### Pre-Application Meeting (PRE23-040 - Location 4)

<b>Site Location:</b>	4350 88th Ave SE, Mercer Island, WA 98040	<b>Parcel Number</b>	4457300325
<b>Lot Size:</b>	3.55 Acres	<b>Zoning:</b>	R-9.6 (Single Family)
<b>Brief Project Description:</b>	The City of Mercer Island Public Works Department (Applicant) is proposing installation of data collection equipment at 4350 88th Ave SE (Rotary Park Water Reservoir Pump Station) to support the Mercer Island Meter Replacement Program.	<b>Documents Provided:</b>	<ol style="list-style-type: none"><li>1. Pre-Application Meeting Request Form</li><li>2. Cover Letter</li><li>3. Application Questions</li><li>4. Project Description</li><li>5. Site Plan</li><li>6. Drawing</li><li>7. Tree Inventory Worksheet</li><li>8. Public Participation Plan</li></ol>
<b>Applicant Information:</b>			
<b>Name:</b> Alaine Sommargren, City of Mercer Island Public Works	<b>Email:</b> <a href="mailto:alaine.sommargren@mercerisland.gov">alaine.sommargren@mercerisland.gov</a>	<b>Phone:</b> 206-275-7879

LIMITED SITE PLAN  
**MERCER ISLAND-CITY OF MERCER ISLAND RESERVOIR**  
 CITY OF MERCER ISLAND

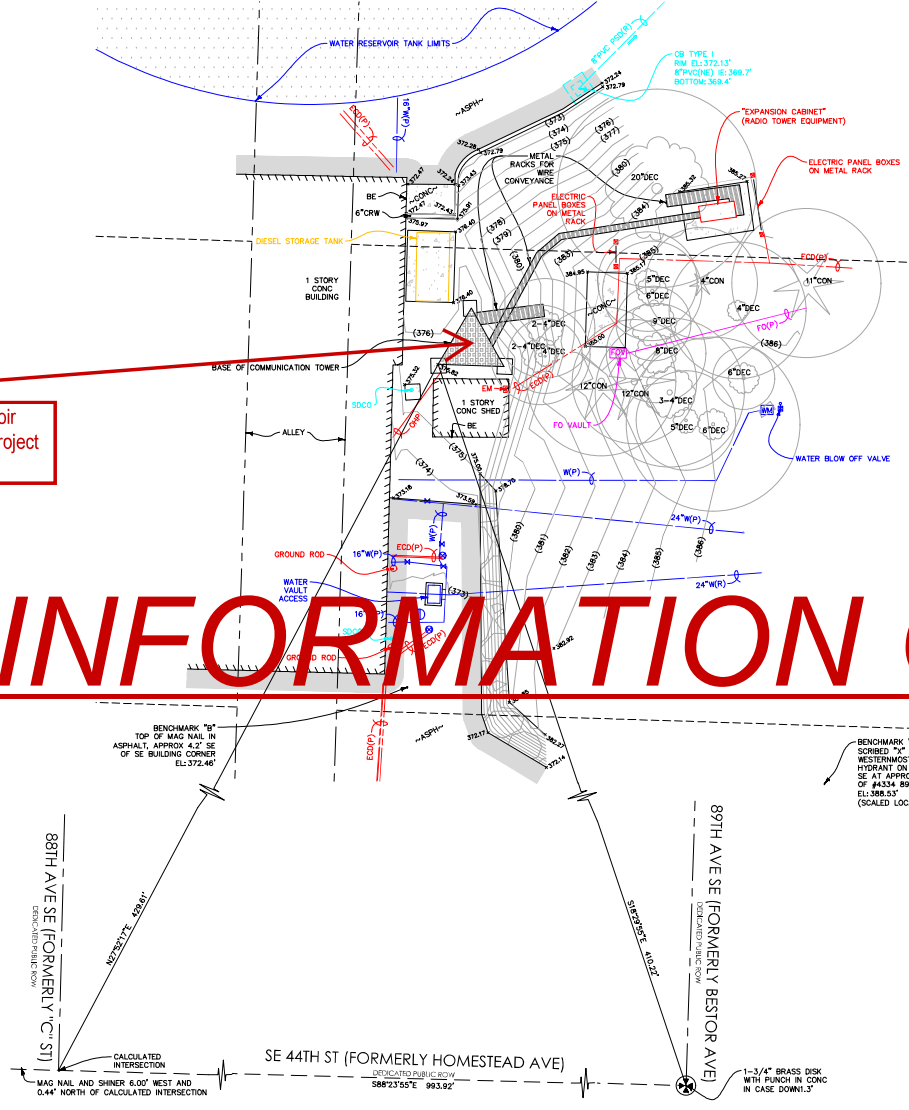
3. The location is shown on Figure 1 is on the City's private property, and the proposal will require building and electrical permits for the work.
4. A statement of risk conforming to the MICC section above is required specific to this scope of work. Your geotechnical engineer may be able to base the statement on available site investigations. If your Geotech doesn't have an extensive history of working with the Mercer Island Geologically Hazardous Areas codes, please have them reach out to [Gareth.reece@mercerisland.gov](mailto:Gareth.reece@mercerisland.gov).
